Substantive response of the Local Highway Authority to a planning consultation received under The Development Management Order.

Planning Application Number: 22/0711/HH

Application Address: Acacia Stanton Road Elmesthorpe Leicestershire LE9 7SH.

Two storey side extension, front canopy, two storey and single storey rear extensions with internal alterations and alterations to vehicular access.

Proposed
Site Block Plan

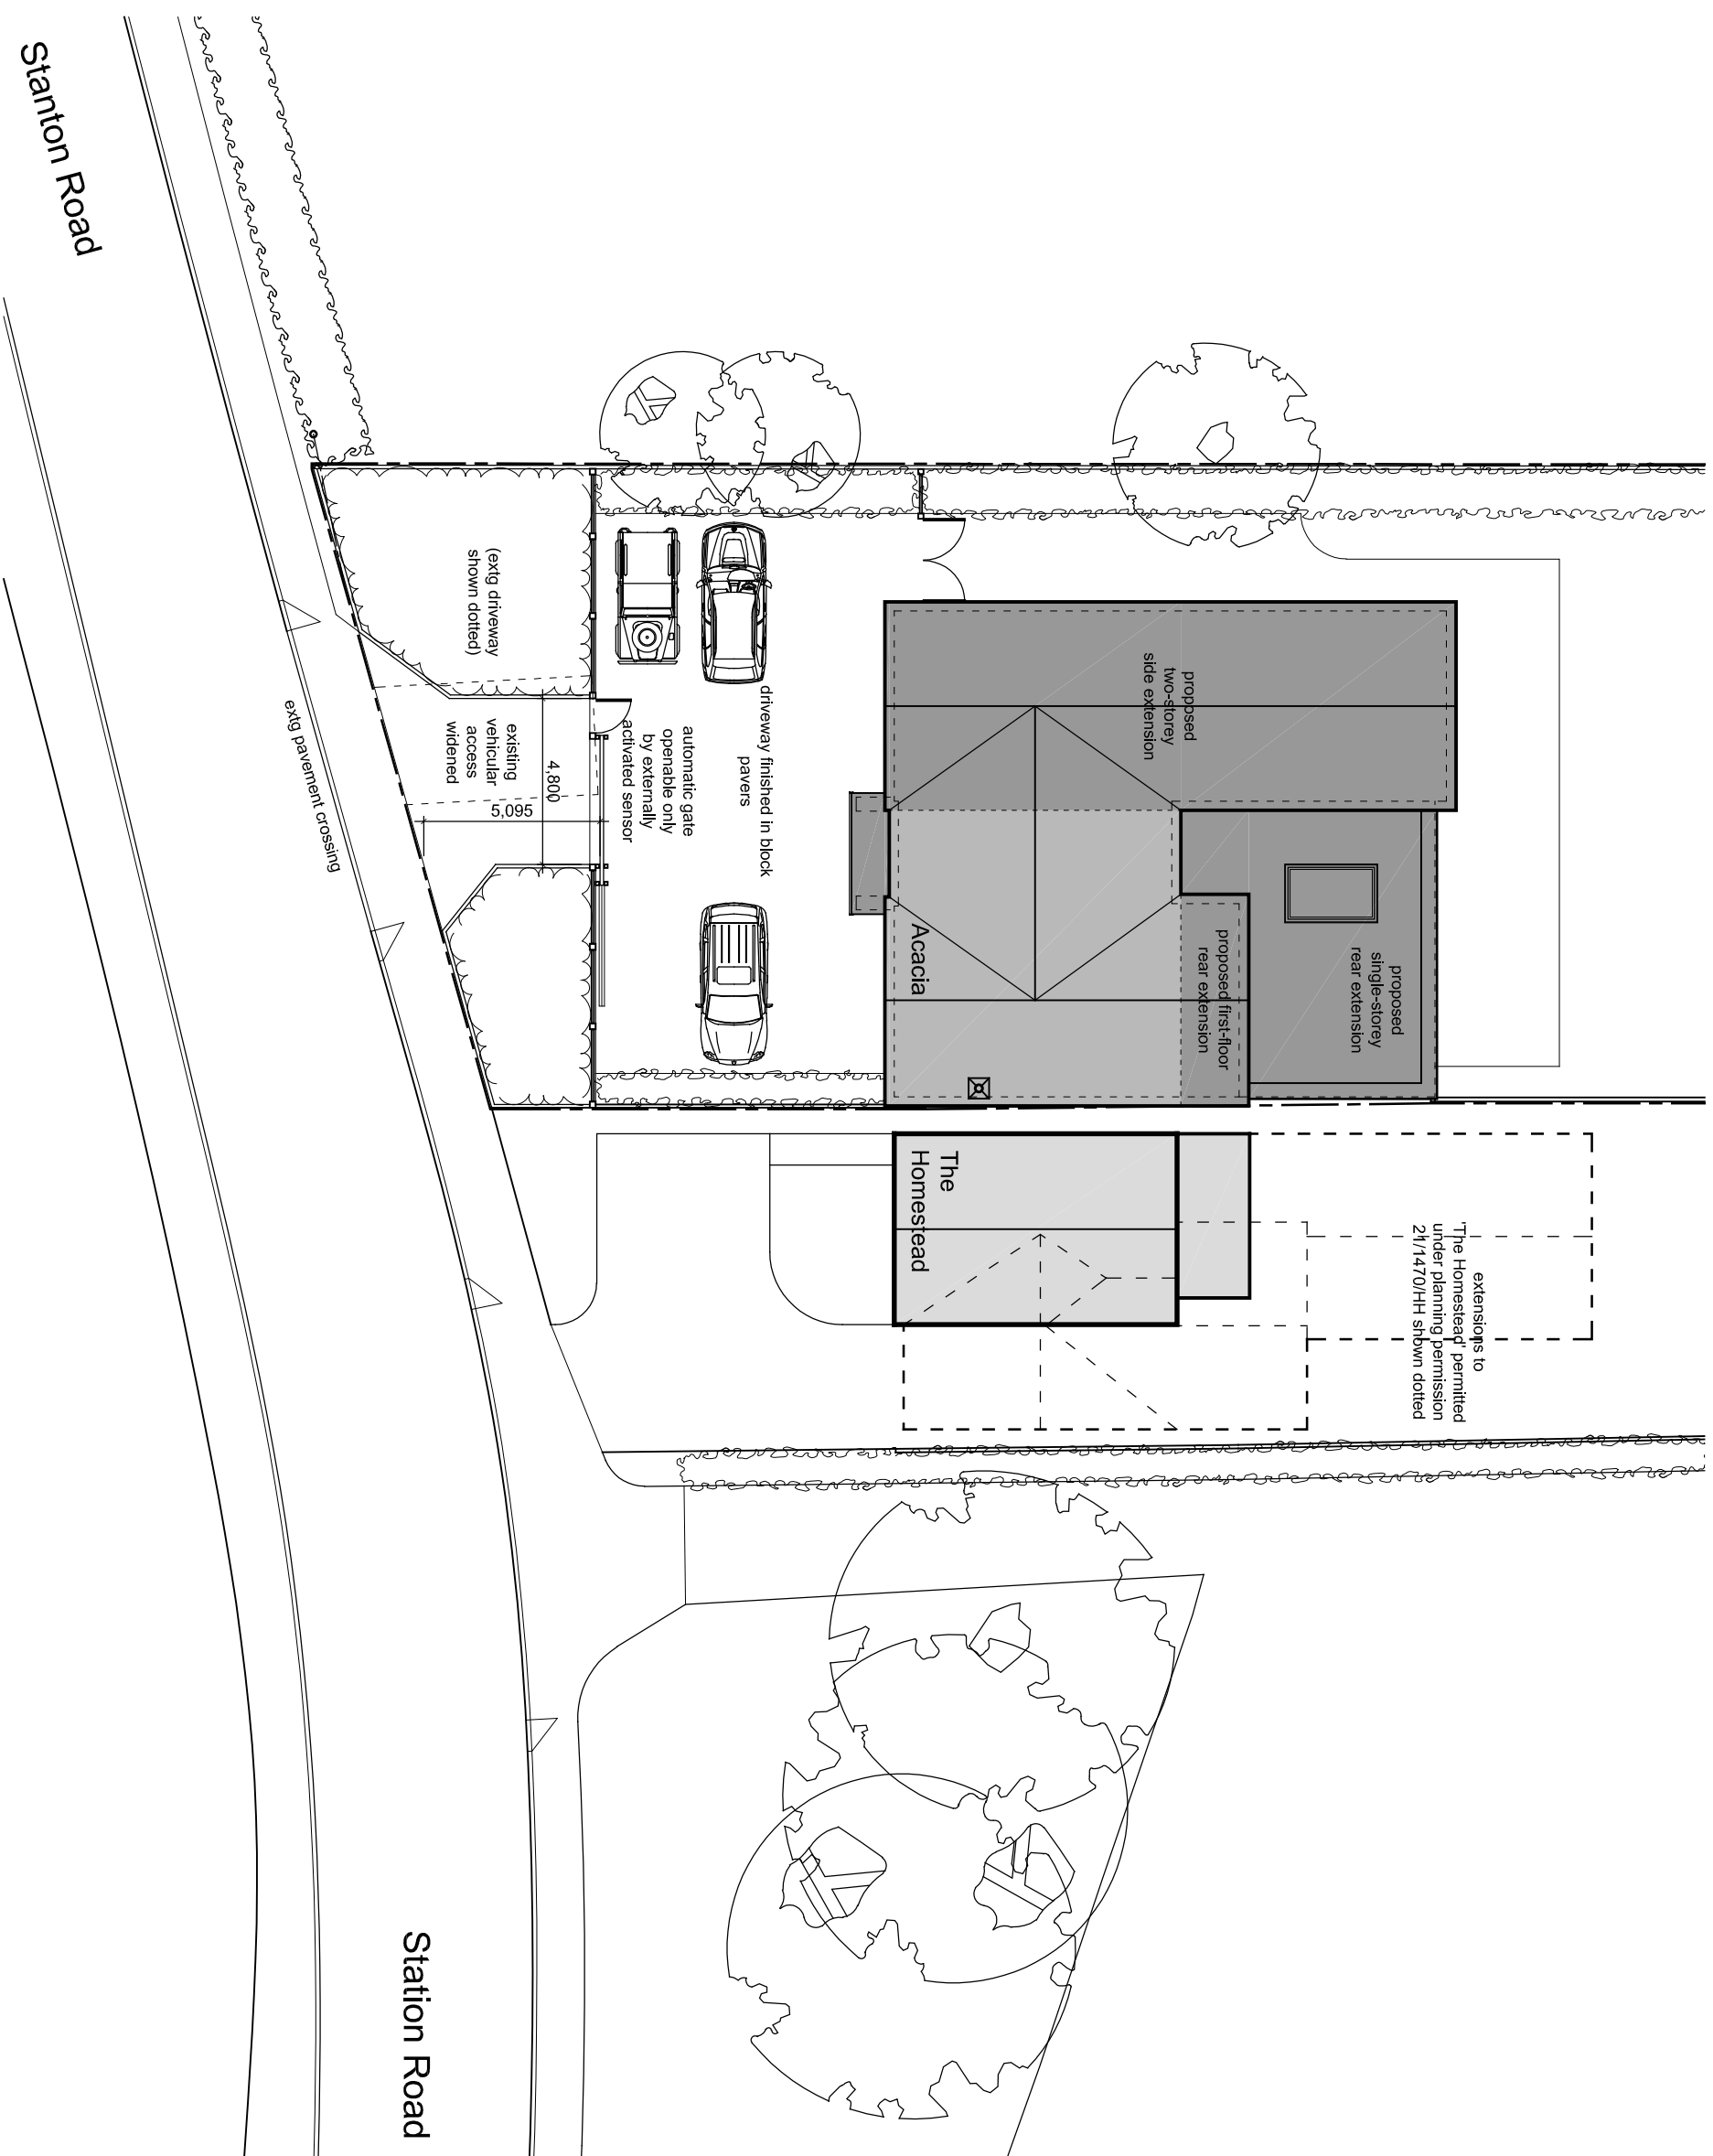
It is noted that the Applicant intends to utilise the existing, albeit amended access. It should also be noted the 'Dropped Kerb Vehicular Access' is already in situ as demonstrated on the 'Proposed Site Block Plan' drawing number (90) 02. As such the Applicant would not require any further permissions or permits from the LHA for this element of the proposals.

It is noted that the Applicant proposes to remove a section of grass verge. Whilst this may be acceptable there may be statutory undertaker apparatus located within the verge/footway fronting the site; the applicant will need to undertake surveys and potentially works to relocate these services. Any additional cost that arises as a result of this would be entirely at the Applicant's expense.

The Applicant should also be mindful of the telecommunications apparatus within the verge as works should not interfere with this. If the telecommunications apparatus requires relocating or another additional works, this would be entirely at the Applicants expense.
